SCOPING OPINION:

Proposed Byers Gill Solar Farm

Case Reference: EN010139

06 December 2022

Drawing Title
**Figure 7.7.1
 Visual Receptors - Before Mitigation
 Matures**

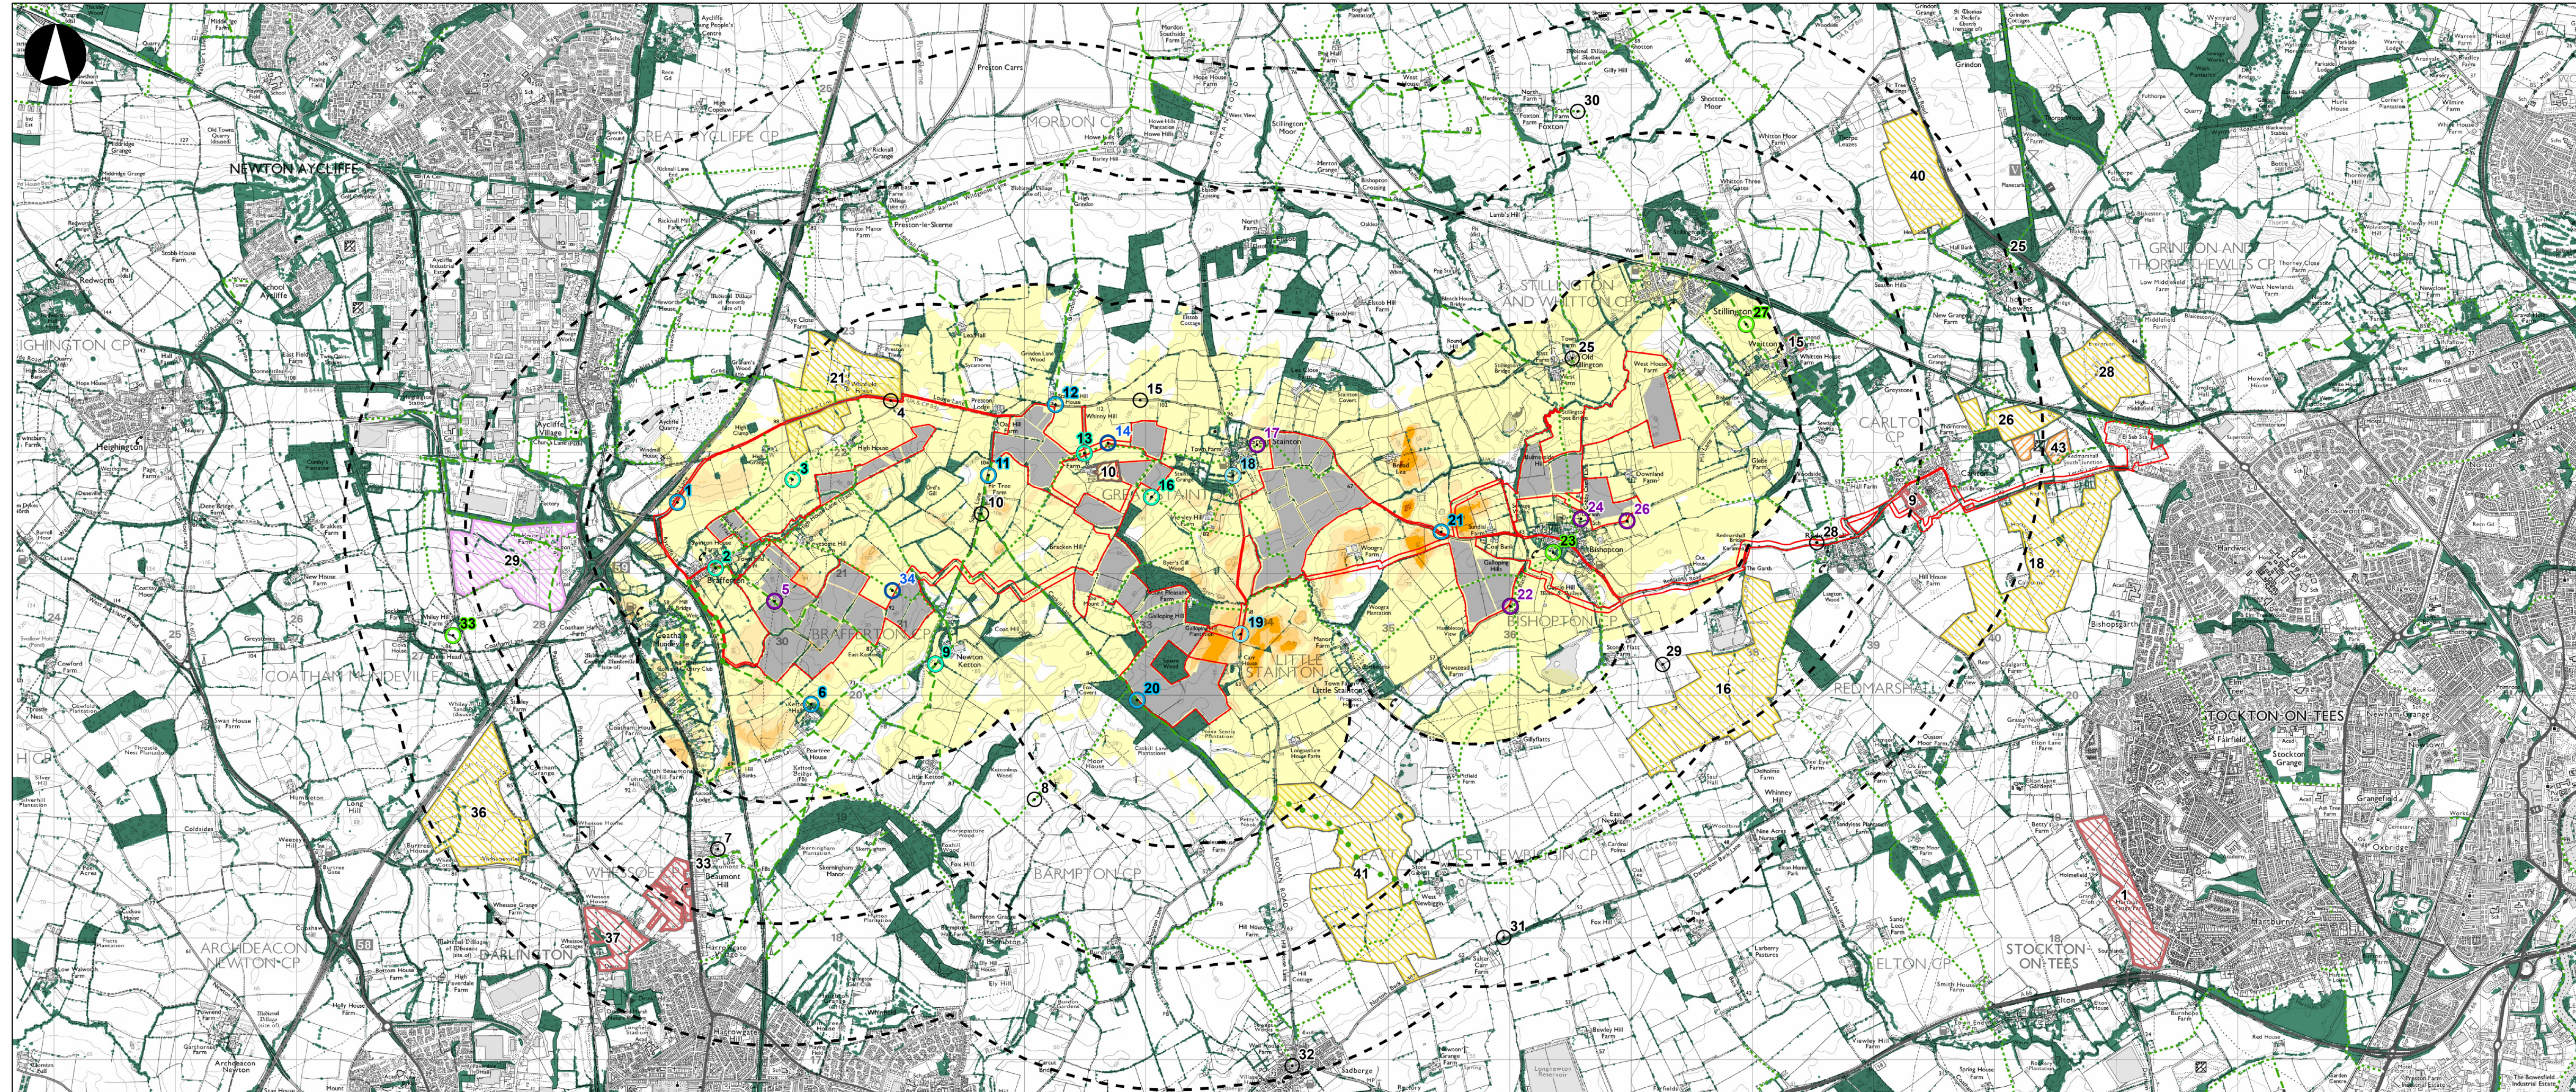
ID	Ref	Applicant's proposed matters to scope out	Inspectorate's comments
3.3.5	Table 7.3; Figures 7.3 to 7.8	Effects on views and visual amenity beyond 2km	The Scoping Report states that effects on visual receptors beyond 2km are expected to be negligible given expected visibility. However, the Zone of Theoretical Visibility (ZTV) illustrated in Figures 7.3 to 7.8 show that the panels will be visible beyond 2km. The ES should assess potential effects on views and visual amenity within the ZTV where significant effects are likely to occur.
